From: Chantelle Bashford <Chantelle.Bashford@arun.gov.uk>
Sent: 11 November 2020 14:29
To: Planning.Responses <Planning.Responses@arun.gov.uk>
Subject: RE: Planning Consultation on: AW/251/20/OUT

Please see comments below from Private Sector Housing.

Application No: AW/251/20/OUT
Registered: 22nd October 2020
Site Address: 14 Princess Avenue Aldwick PO21 2QT
Grid Reference: 492444 98779
Description of Works: Outline application with some matters reserved (landscape reserved) for the proposed conversion of existing dwelling into 4 No. flats including single & two storey rear extensions & first floor extension over garage.

CLIENT	Mrs B Woodland	DRAWING	002 Proposed Floor Plans
SITE	14 Princess Avenue, Aldwick	DATE	10 09 20
PROJECT	Proposed Conversion to Flats	SCALE	1: 100 @ A3
		AUTHOR	AH
		STATUS	DRAFT

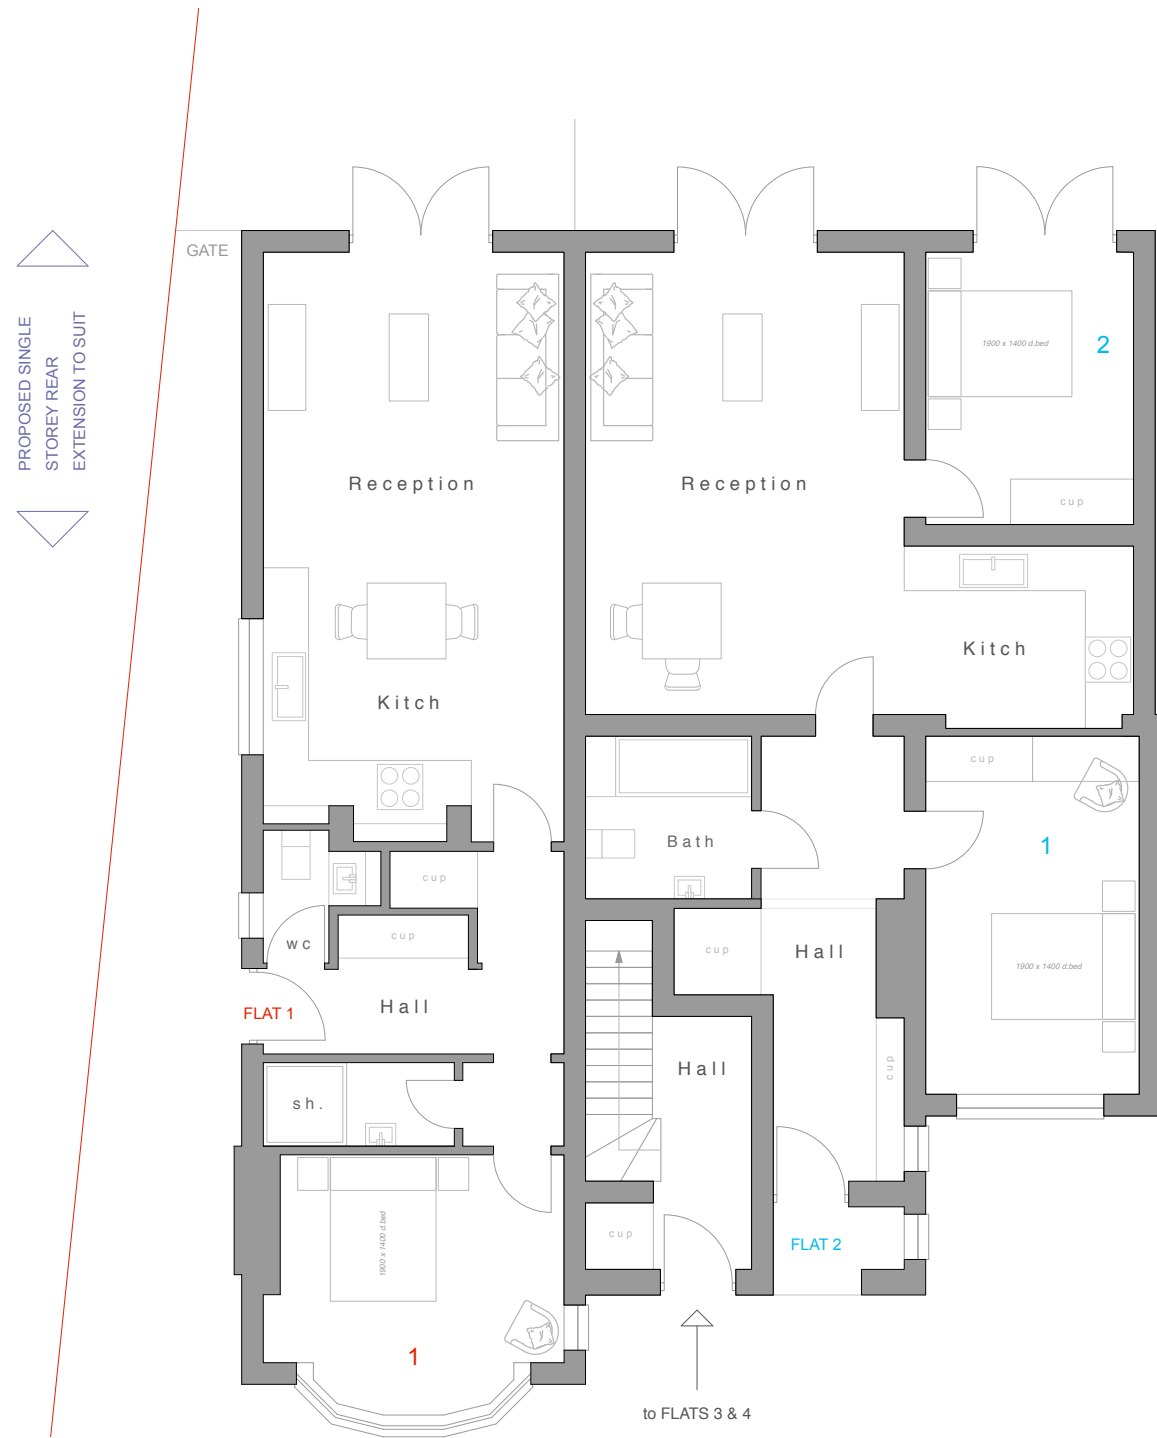
- Non-interlinked mains-wired smoke alarm with integral tamper-proof battery back-up located within the hallway/lobby of each flat
- The internal escape route should provide 30 minutes fire resistance, including the provision of 30-minute fire resisting and self-closing fire doors (FD30S) to the entrance of flats 3 & 4

- The rear bedroom in Flat 2 is classed as an inner room, whereby the only escape route is through another room and poses a risk to its occupiers if a fire starts unnoticed in the outer room; particularly in this instance where the inner room in question is a bedroom and the outer room is a high-risk room. Therefore, egress via the double doors should lead to a place of ultimate safety. If egress leads into a courtyard or back garden where there is no exit, it should be at least as deep as the building is high

- The rear bedroom in Flat 2 does not appear to have an openable window casement, only double doors. Consideration should be given to installing an openable window casement to enable the occupiers of the room to have better control over ventilation. This could be within the design of the door unit itself, or the double doors could be replaced with an escape window (to still provide egress from the property as this is an inner room). An escape window should only be installed if the following criteria can be met:
